DRB CASE NO/PROJECT NO: 1002404

SUBJECT: Project # 1002404

On November 15, 2007, the Environmental Planning Commission approved Project # 1002404/07EPC-40050 and 40051, a request for a site development plan for subdivision and a site development plan for building permit for Lots 1B and 1D, Ladera Industrial Center, located Unser and Vista Oriente NW.

Lots 1-B & 1-D, Ladera Industrial Center

DATE: 10/25/07
SCALE: 1"=40'
SHEET: AS.2

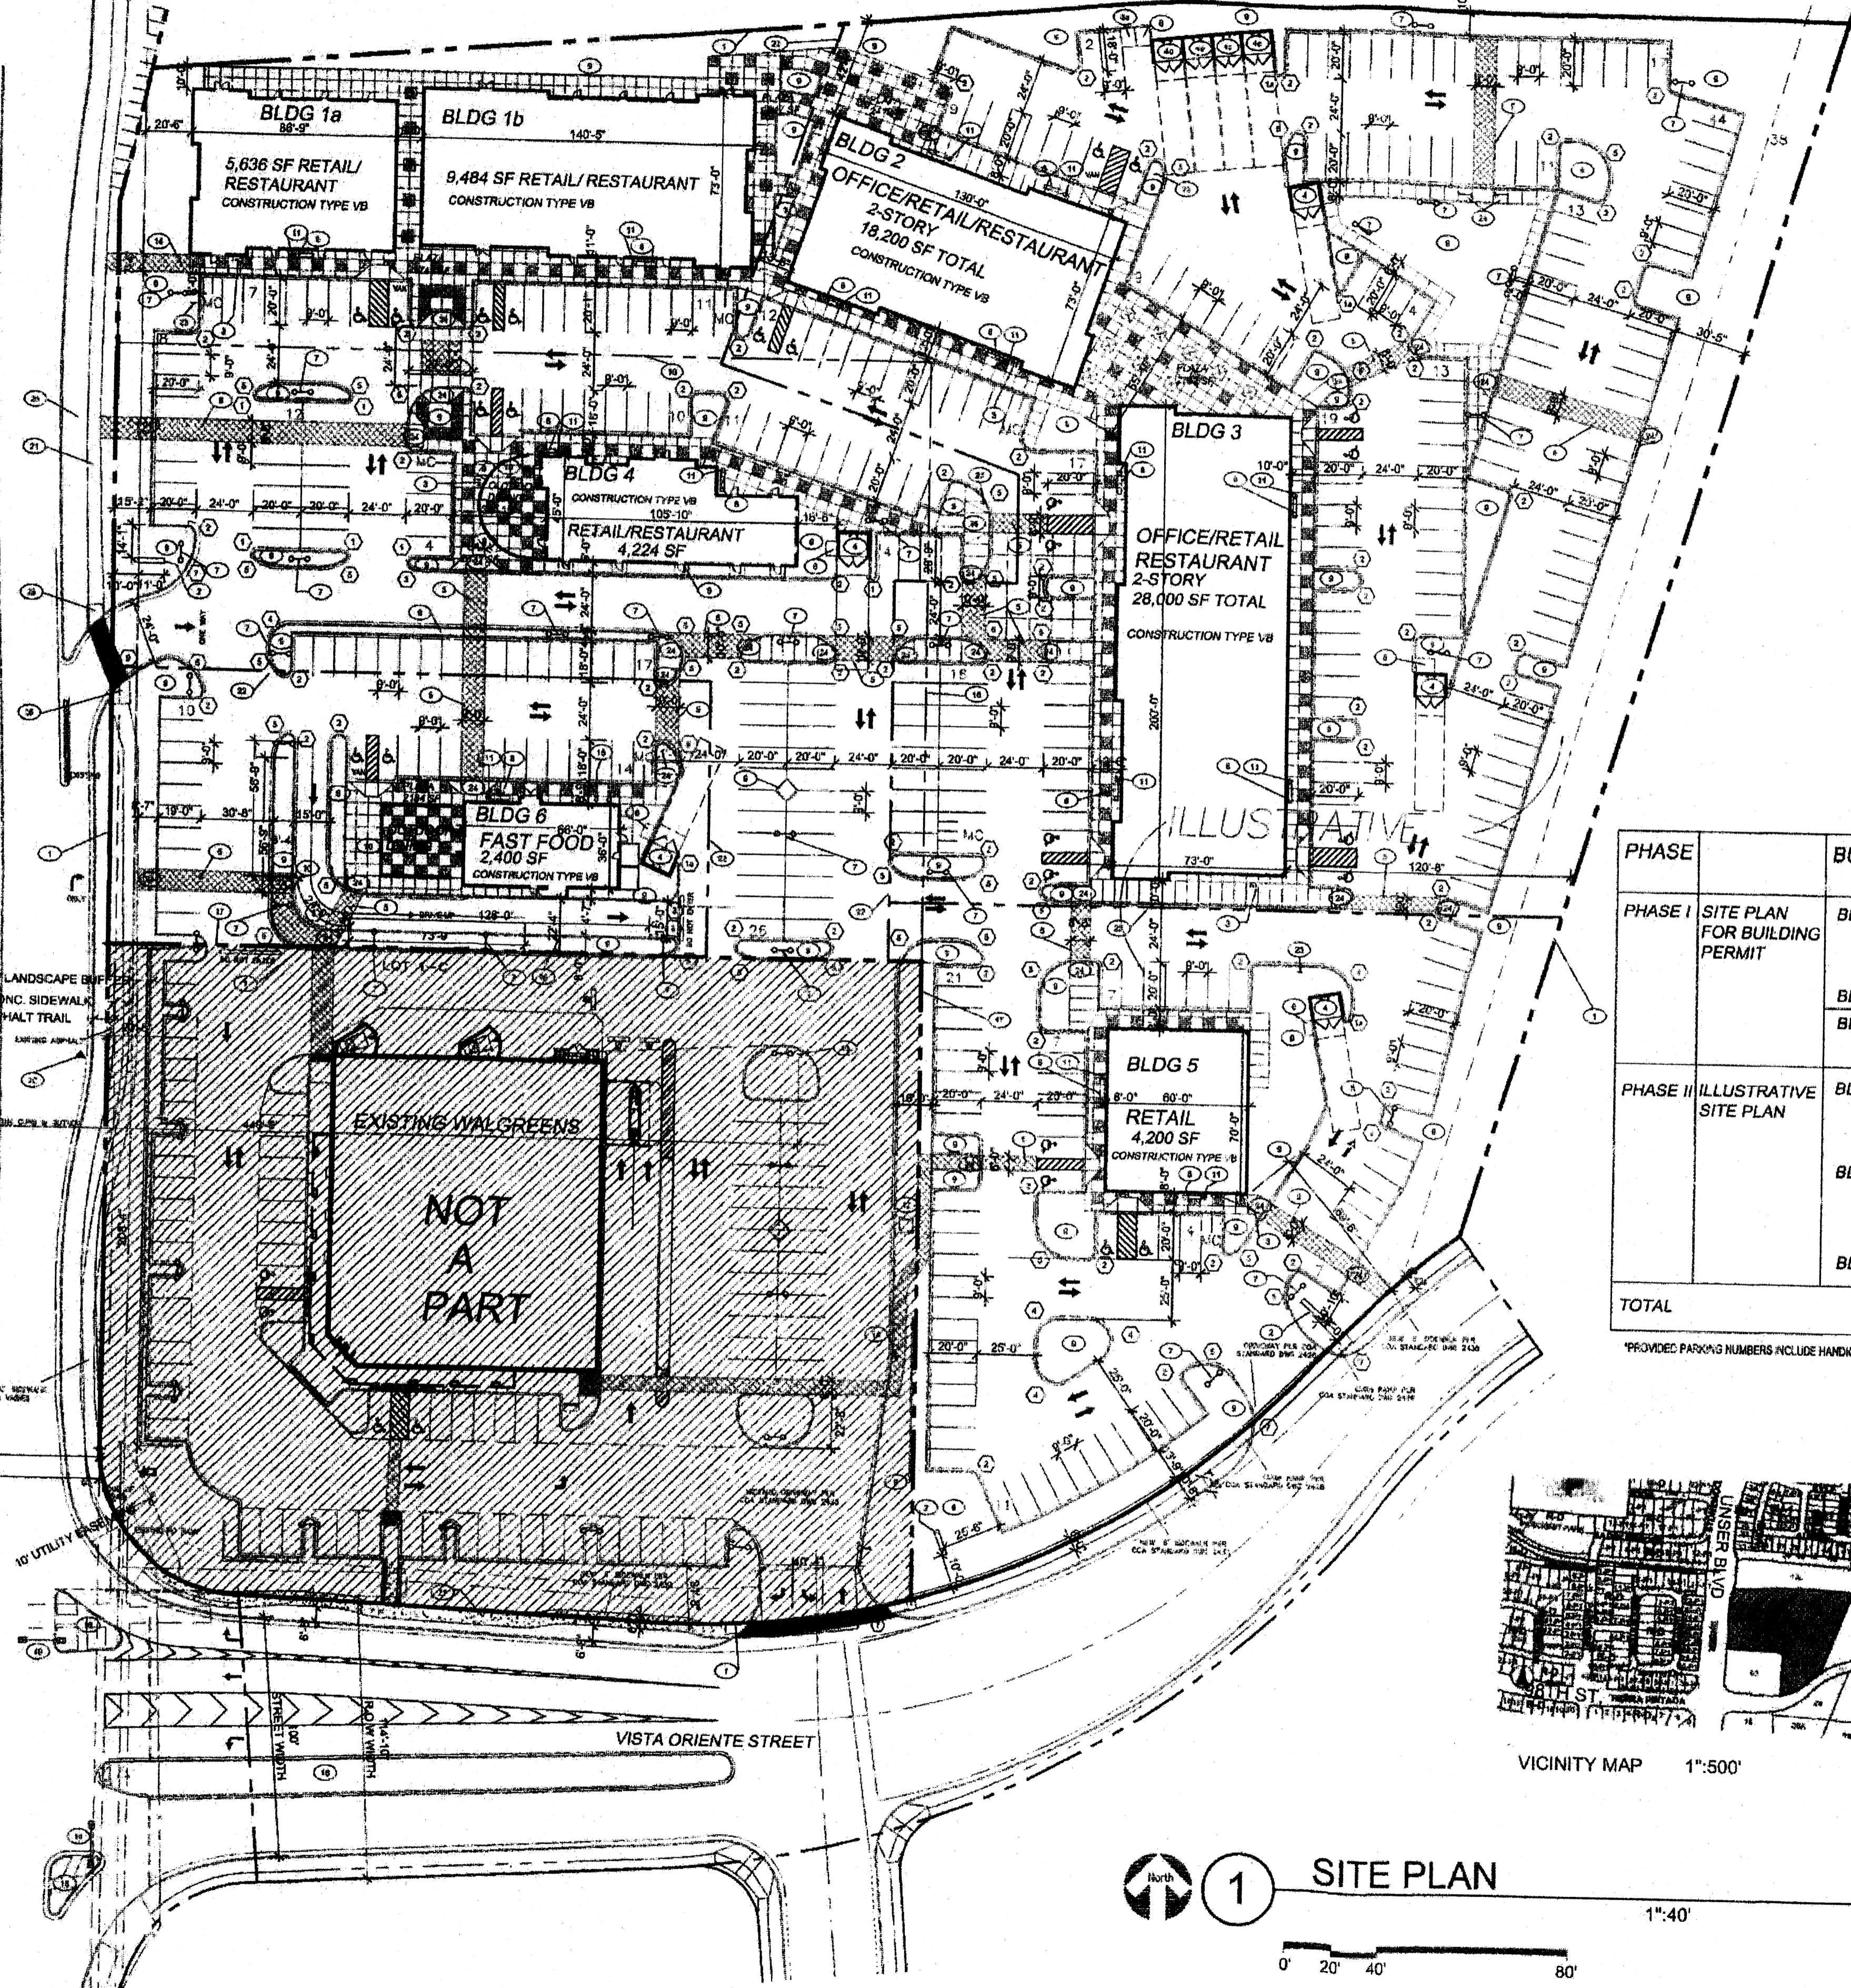
There should not be sidewalk on Unser it should be trail. Confirm if trail is existing.

NMDOT concurrence is required prior to approval.
Portions of the public sidewalk are located outside of the right of way. These sections will require a sidewalk easement
Show a detail for all wheelchair ramps, or refer to the appropriate city standard.
A 6-foot wide, ADA accessible, pedestrian path must be provided.
Cross lot access easements are required.

LANDSCAPE PLAN
0' 20' 40' 80' 1:40'

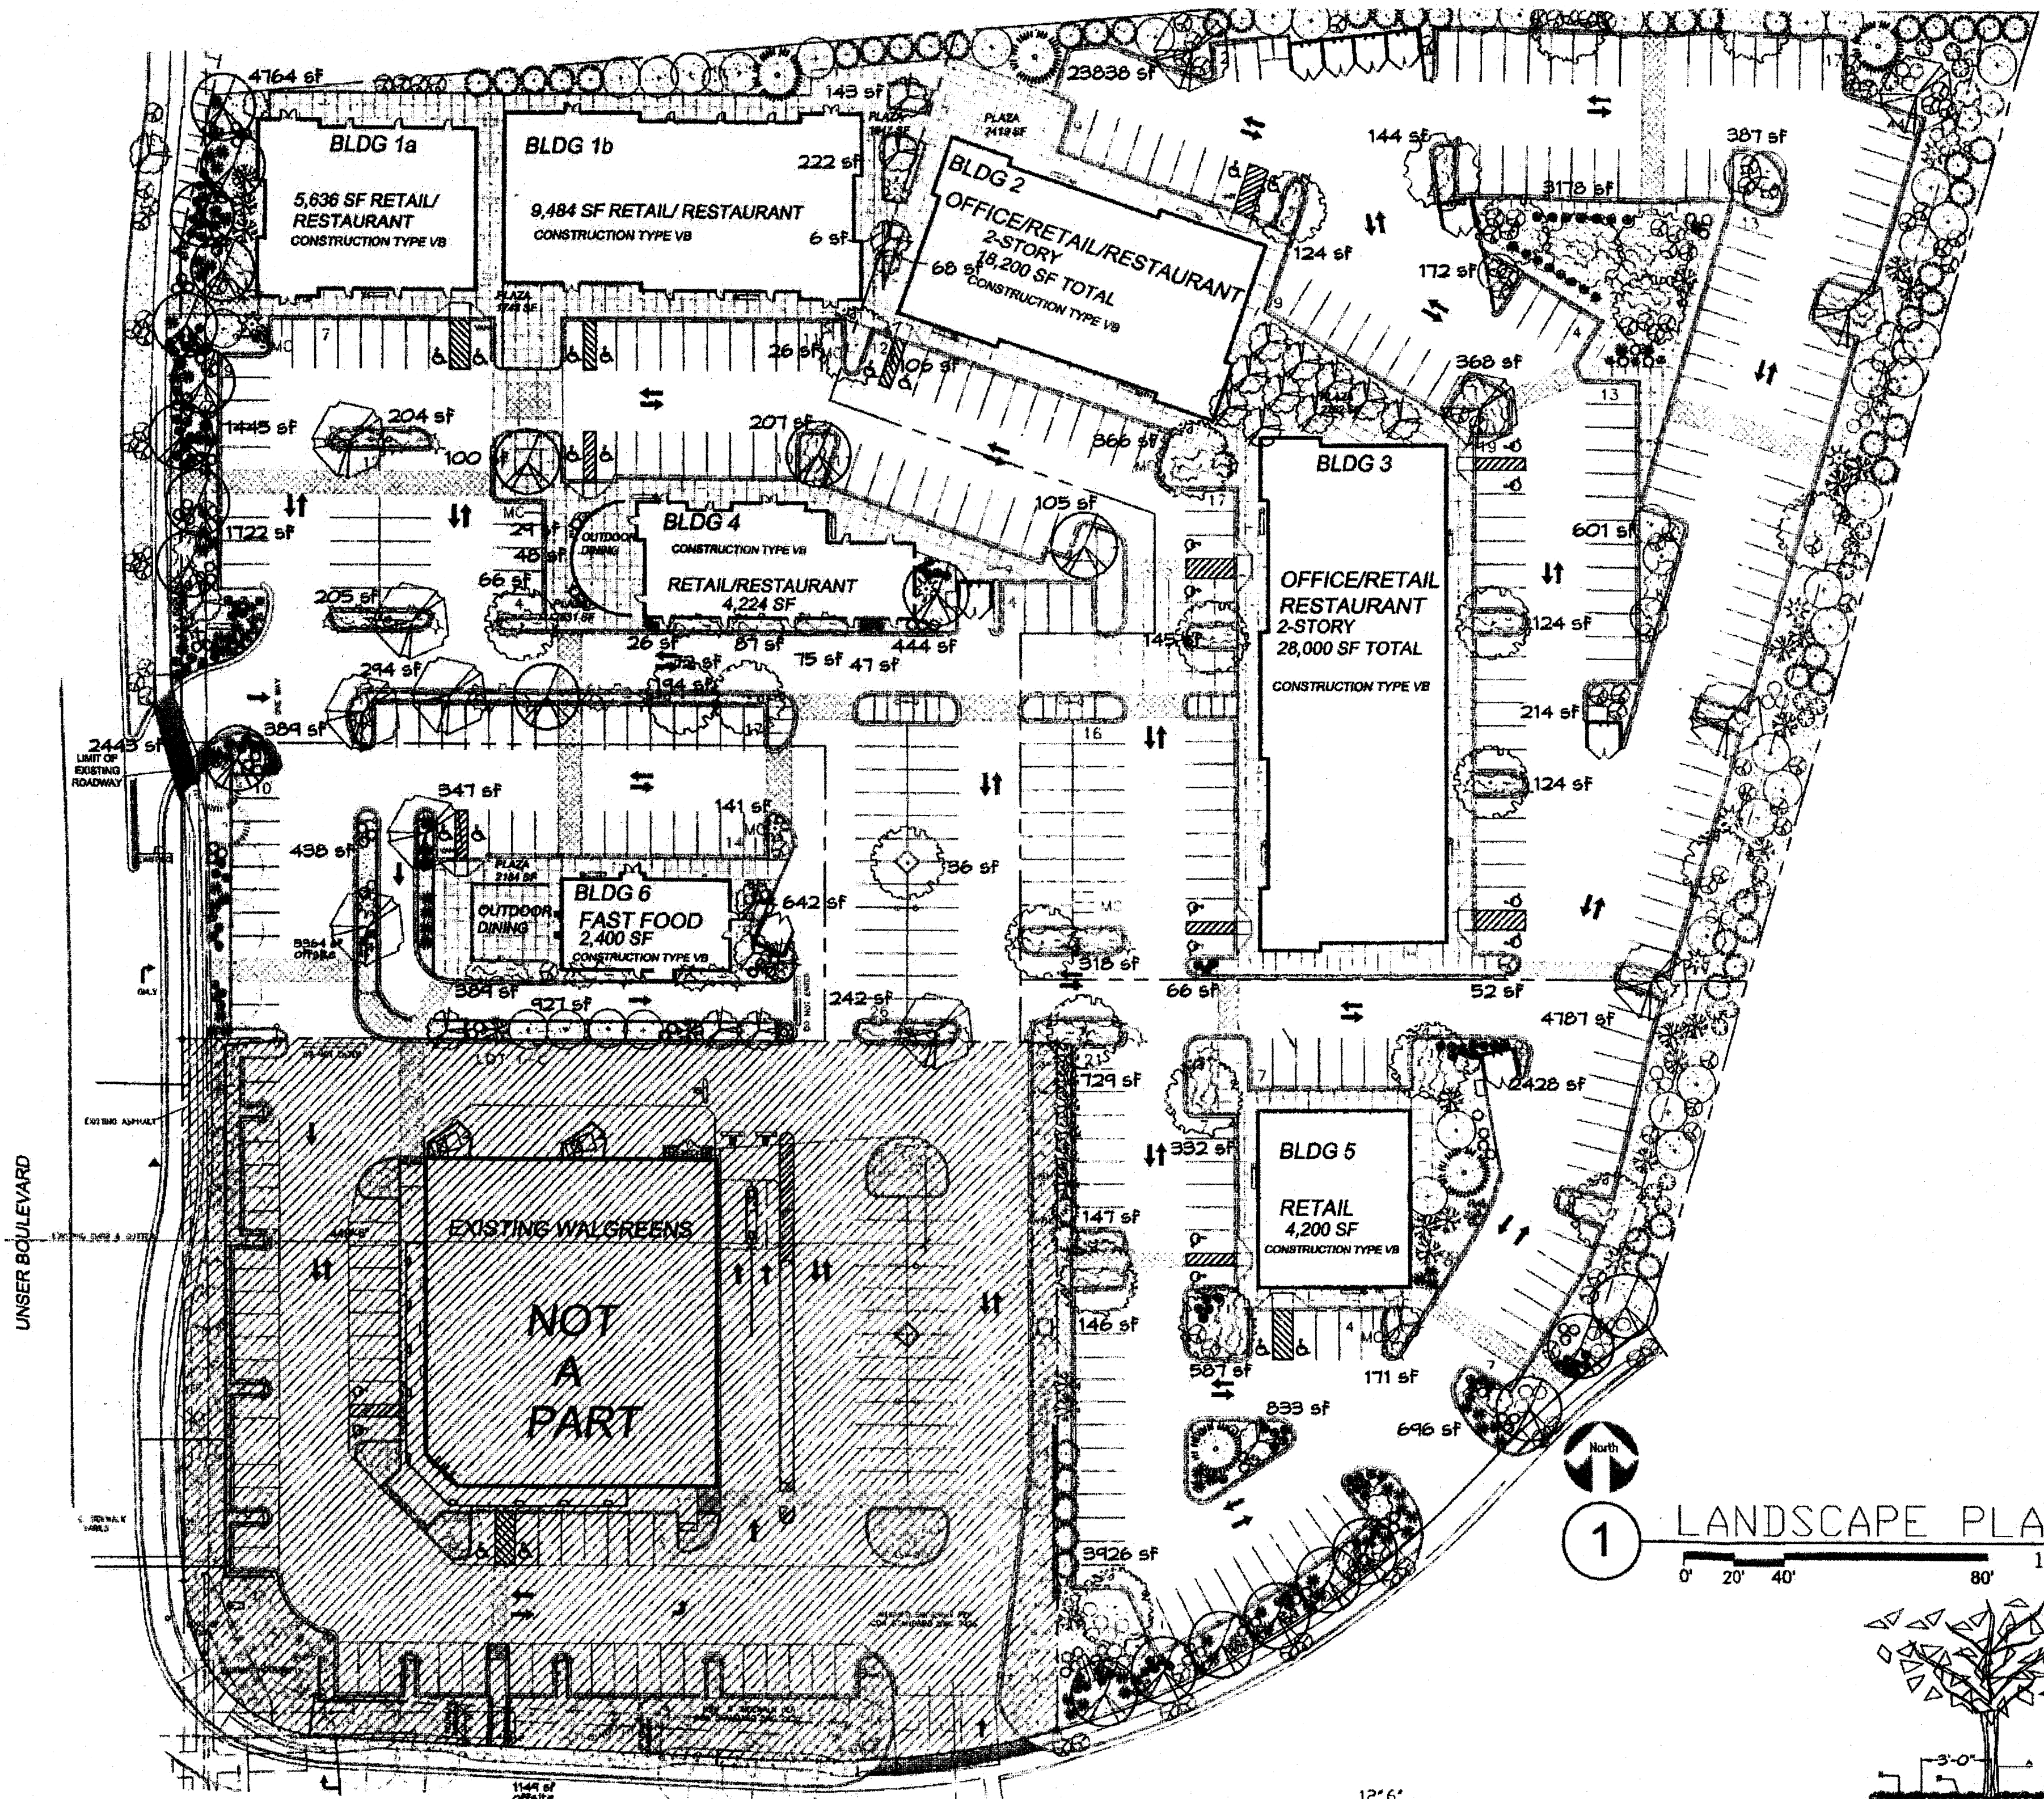
1. Condition #3c requires the applicant to specifically state that 75% live groundcover shall be provided for **each** landscaping area.
2. Condition #3e allows the applicant two 12-foot signs along Vista Oriente. As written, the design guidelines would only permit one such sign. The applicant should be made aware that the current language of the design guidelines is more restrictive than what the EPC approved.
